Date: 22-Mar-2024
Our Ref: 2024/90341

**Discharge of conditions 4 (CMP), 5 (CEMP), 6 (surface water drainage), 11 (foul / surface drainage), 20 (BEMP) and 22 (invasive species) of previous permission 2023/91408 for erection of care home (Class C2) with sub-station, associated car parking, access, servicing, landscaping and other associated works
Land adj, 21, Thomas Street, Lindley, Huddersfield, HD3 3JJ
Application Number: 2024/90341**

Split decision:

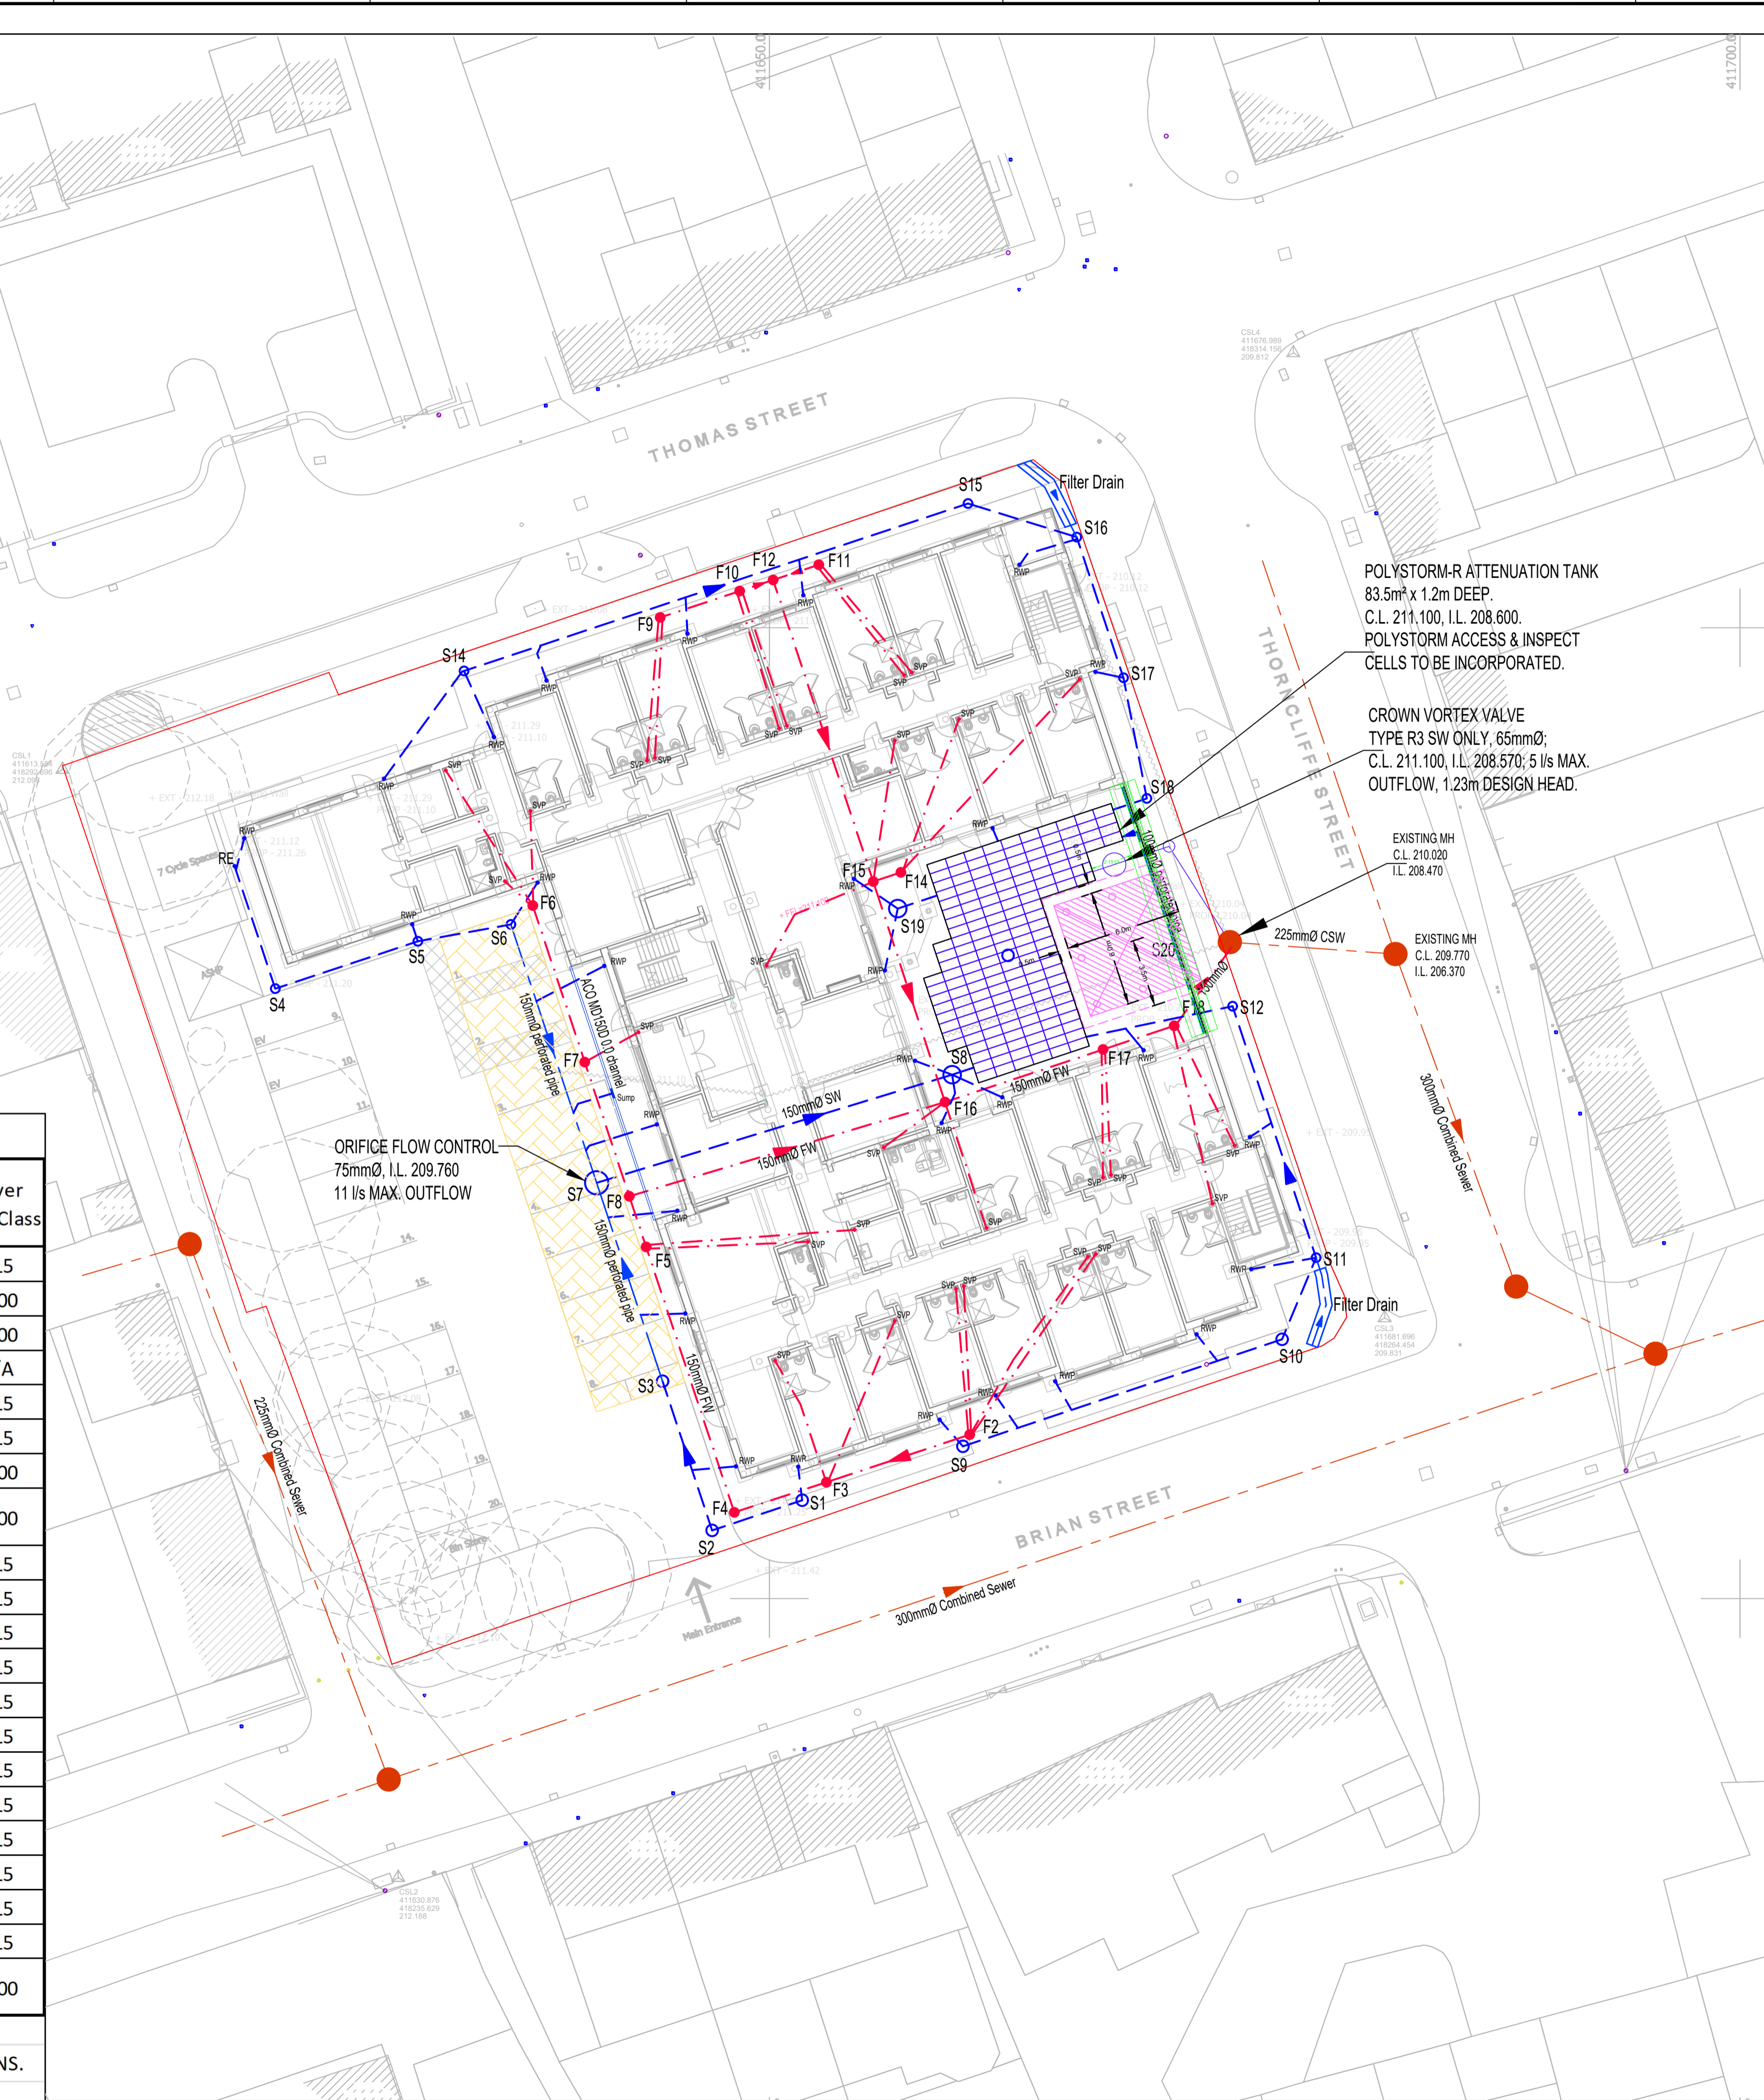
A Proposed Drainage Layout, reference 500 Revision D, has been submitted. The Lead Local Flood Authority has commented as follows:

- Drawing is stamped “Work In Progress” – but it is not clear what further changes or updates are proposed.
- The drawing shows a Polystorm R Attenuation Tank but calculations confirming its size have not been provided.

- Surface water manholes S12 and S18 upstream of attenuation tank will need to be catchpits as these are connected to filter drains.

Further information and amendments are required as noted above and therefore condition 11 cannot be discharged at present.

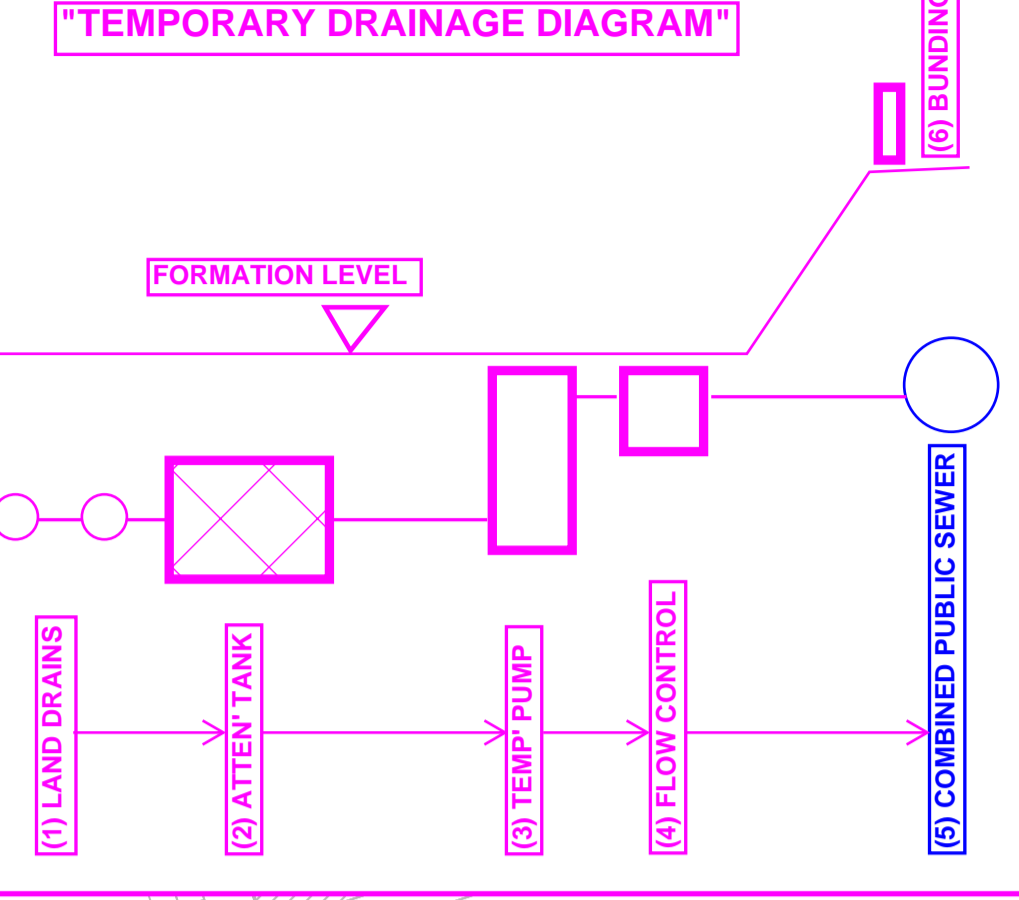
A temporary drainage diagram, forming part of drawing 500 Revision D, has been submitted. The Lead Local Flood Authority has commented as follows:

- The drain from the temporary storage tank (Item 2) is shown passing under the crane mat (also Item 2) and is not shown connecting to the temporary SW pump chamber (Item 4).
- It does not provide details of how the flow rate from pump chamber will be controlled to be no greater than 2.5 l/s per ha as stated in condition 6.
- Calculations should be provided confirming that the temporary storage tank is of sufficient capacity for the critical 1 in 2 year rainfall event with the outlet controlled to the above rate.

Further information is required as noted above and therefore condition 6 cannot be discharged at present.
